Project# 1004976

BORDENAVE DESIGNS agents for CALABACILLAS GROUP request the referenced/above actions for the P.U.E. on, and a portion of GOLF COURSE RD NW adjacent to, Tract A-1-A-1 **BLACK ARROYO DAM**, located on the west side of GOLF COURSE RD NW between WESTSIDE BLVD NW and the CALABACILLAS ARROYO containing approximately 8.0350 acres. (A-12)) [Deferred from 4/23/14, 5/7/14, 5/21/14]

Ref: Response to Review Comments May 15th DRB meeting- 13EPC 40091- HME Healthcare-
Westside and Golf Course

DEVELOPMENT REVIEW BOARD – SPEED MEMO

PROJECT #: 1004976  
 DATE: 6-4-14  
 APP#: 14-70185(SDV)

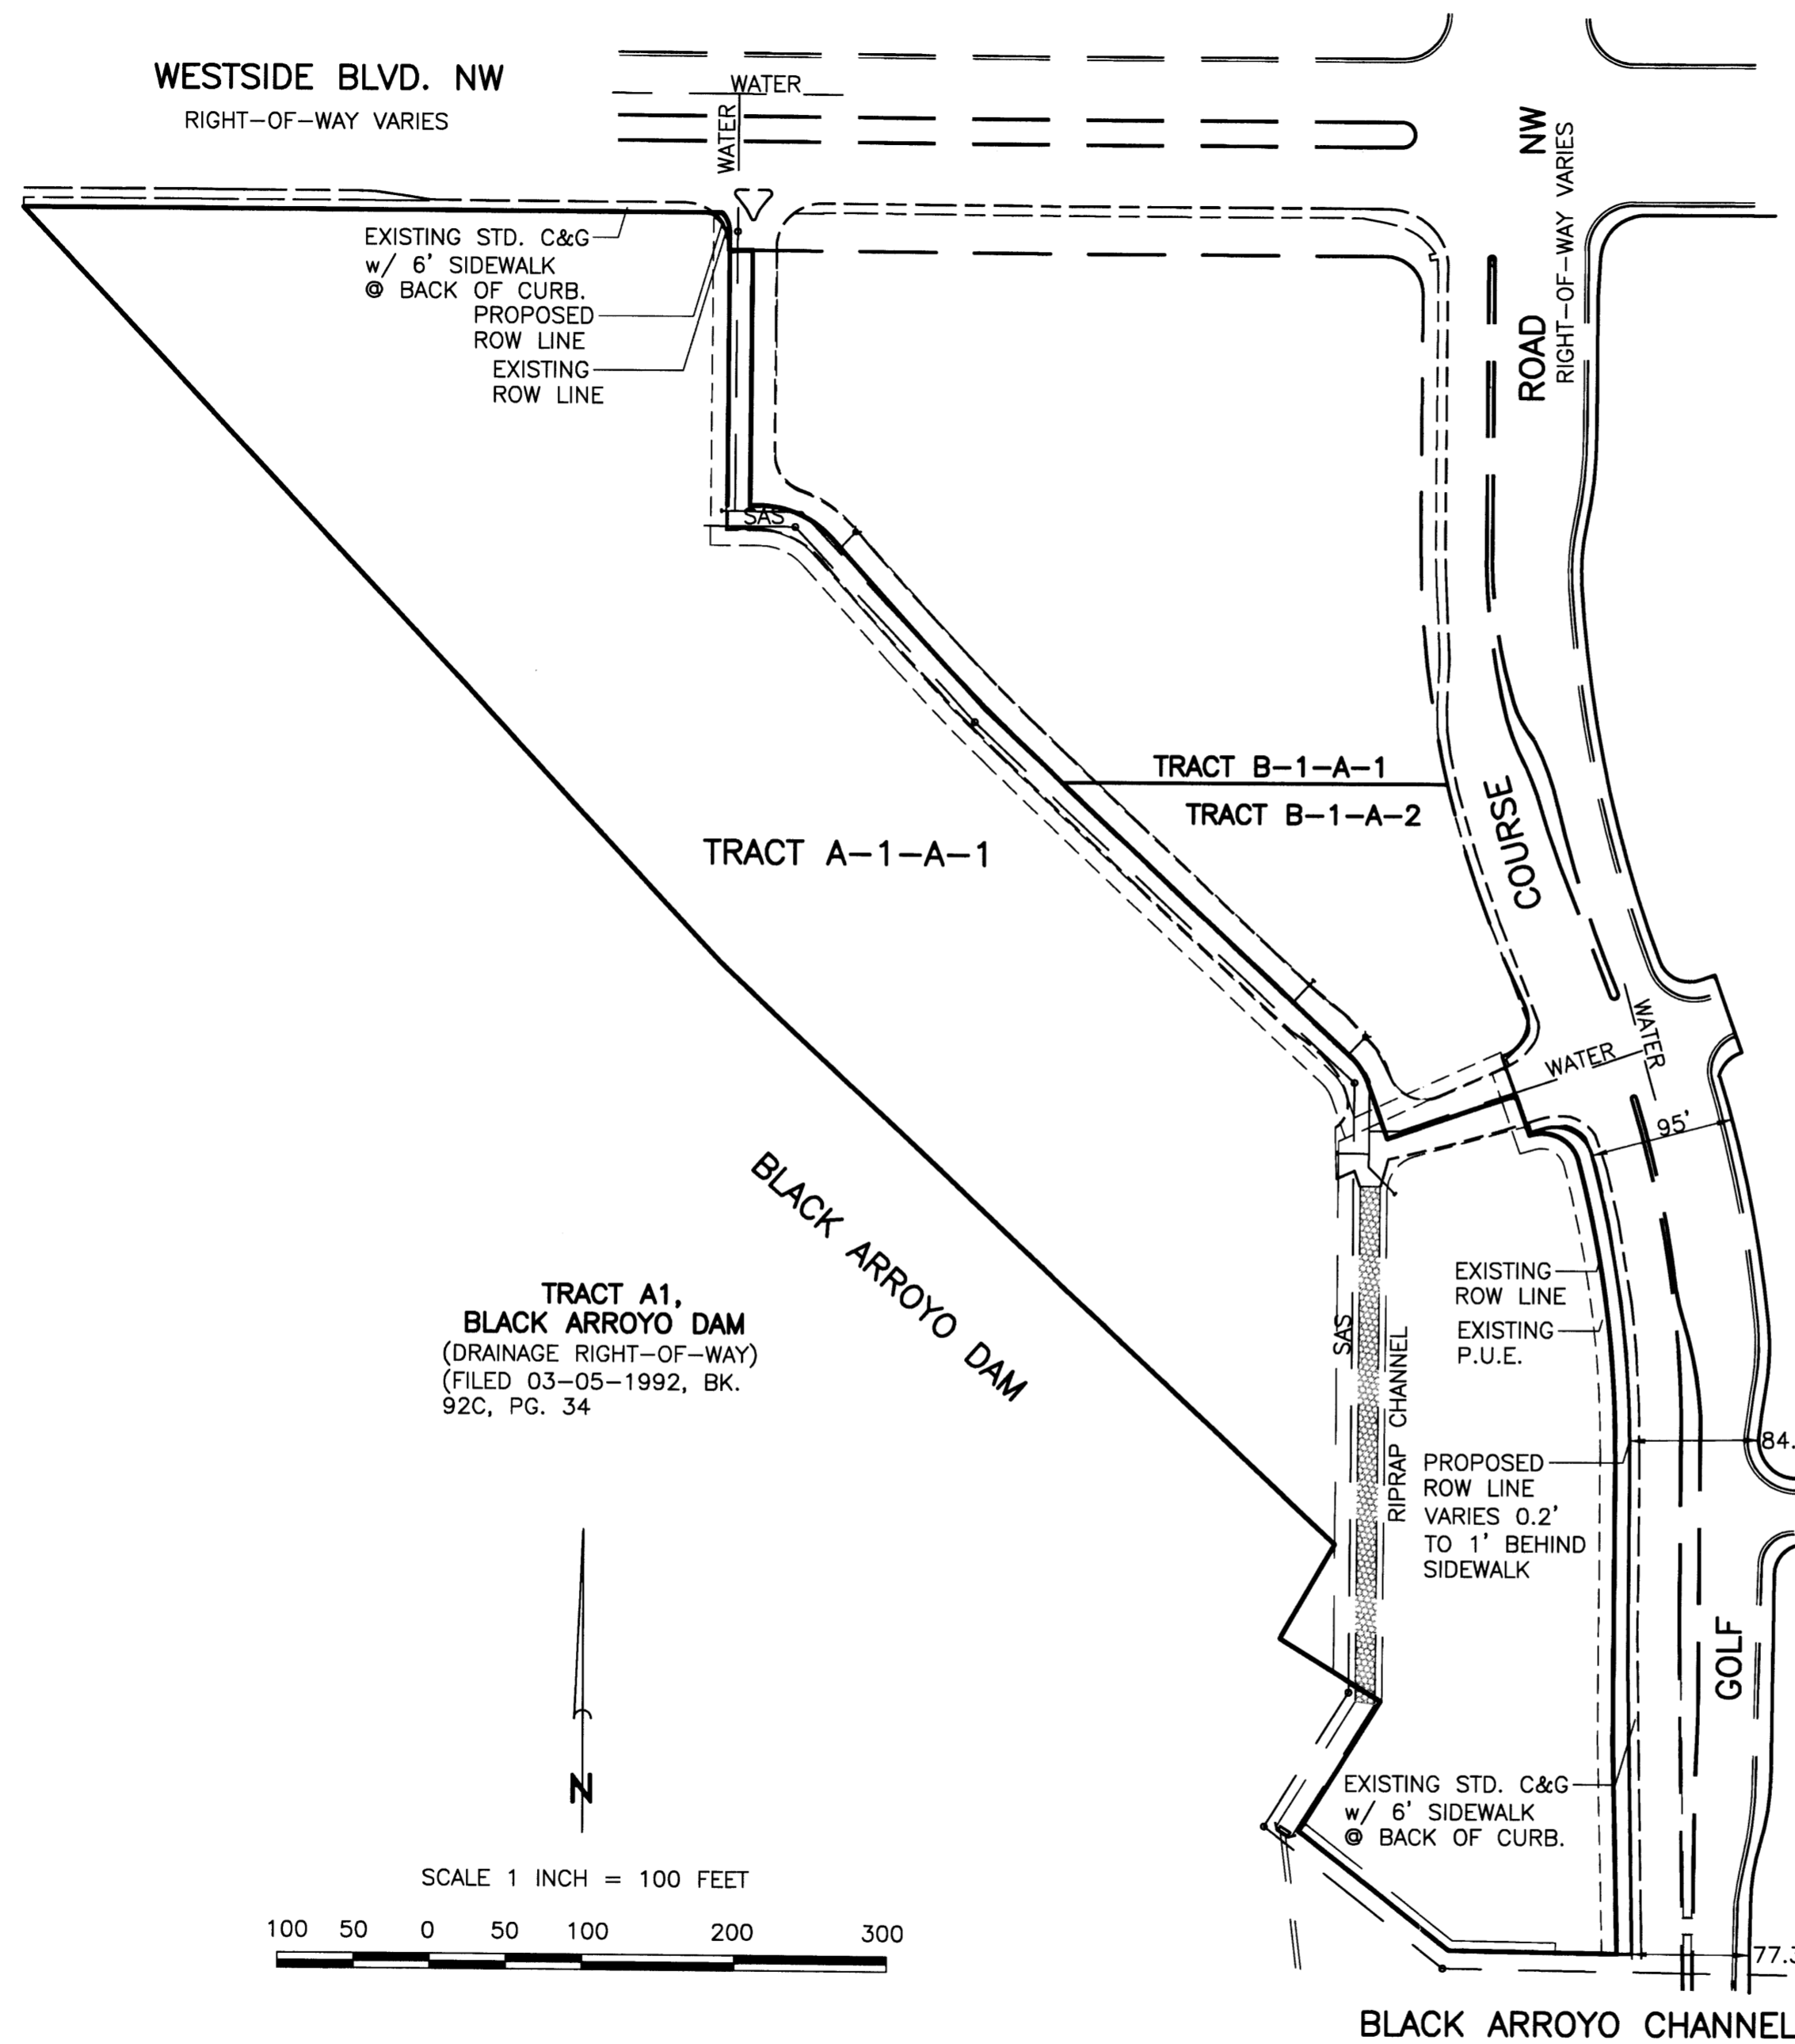
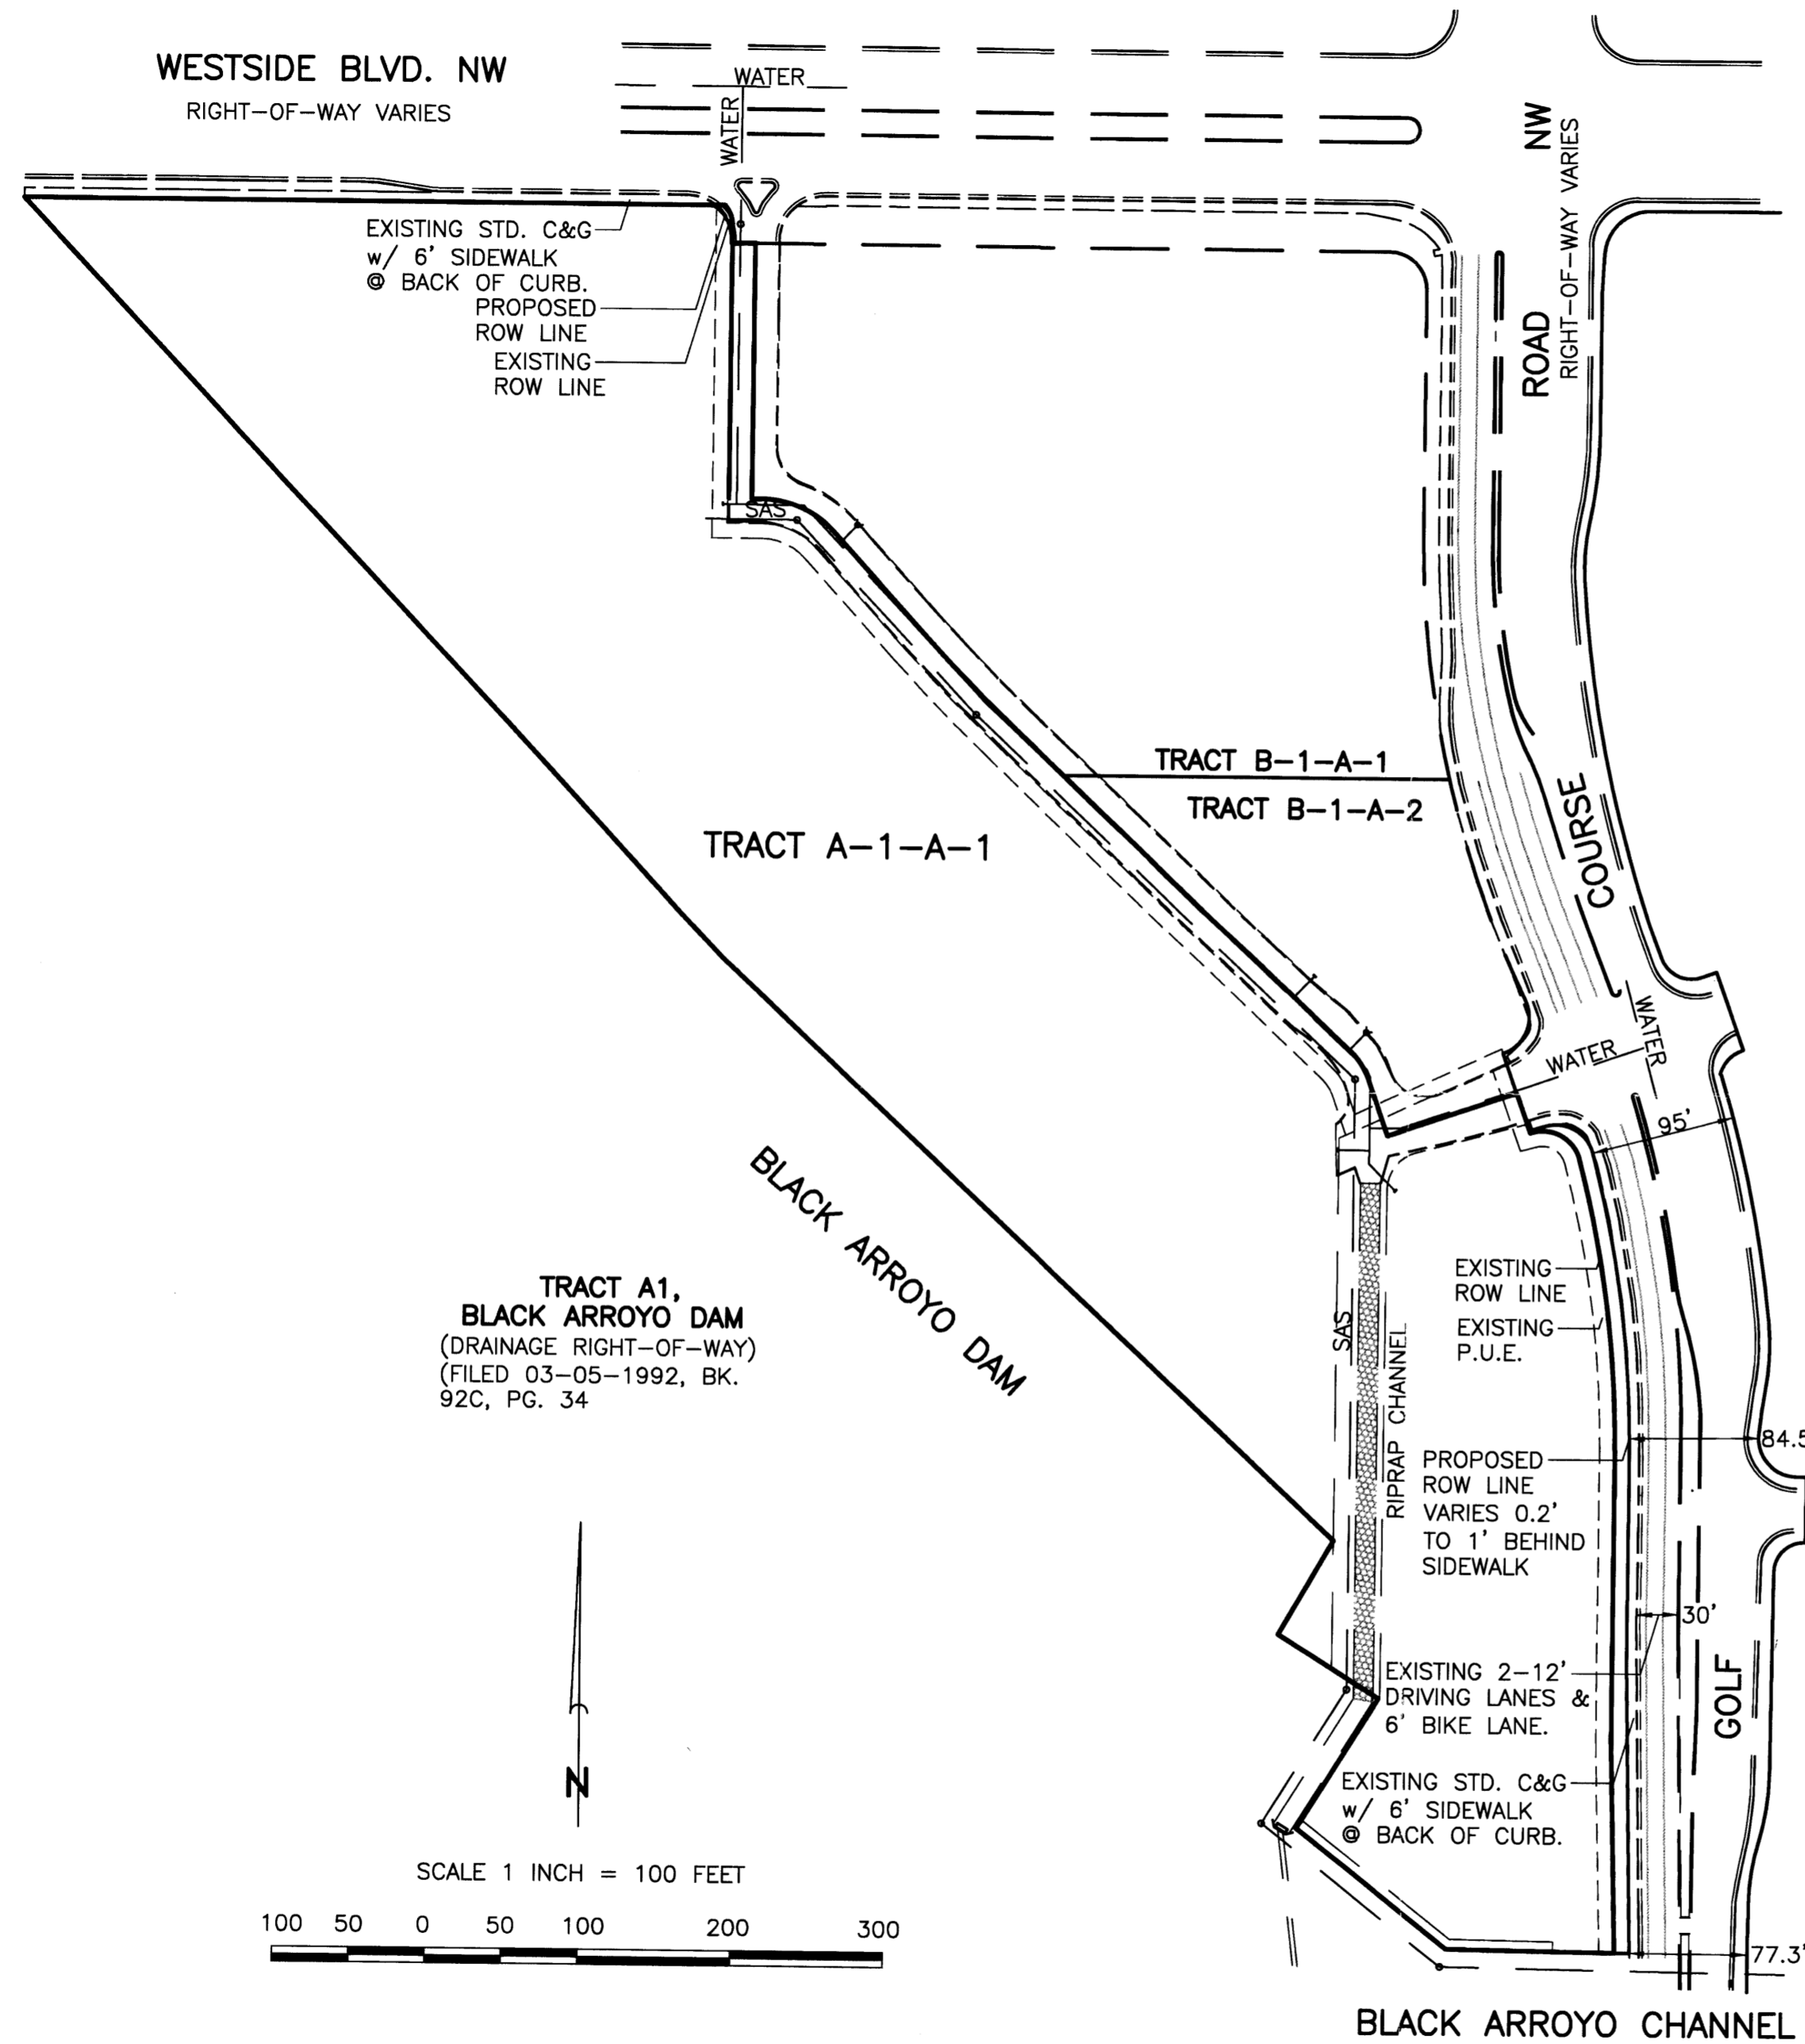
An application for a Subdivision Design Variance must be made to support the vacation application. Call out dimensions and indicate total R-O-W and pavement widths, both existing and proposed. The exhibit must include dimensions for the existing plus proposed distances from back of curb to property line.

The submittal letter notes a previous vacation on the east side; however, a review of the file 1002556 does not show a vacation across from the current request but instead a dedication for a deceleration lane. The distance from back of curb to property line is noted as 10 feet; this was adjacent to a deceleration lane. Additional information must be provided.

At the April 14, 2014 Development Review Board meeting, the vacations were approved to allow the property line to be 10 feet behind the curb per the DPM per section 14-14-7-2(a) (1) and (b) (1)(3) of the subdivision ordinance. A subdivision design variance from minimum DPM design standards was approved as shown on the applications and exhibit in the Planning file
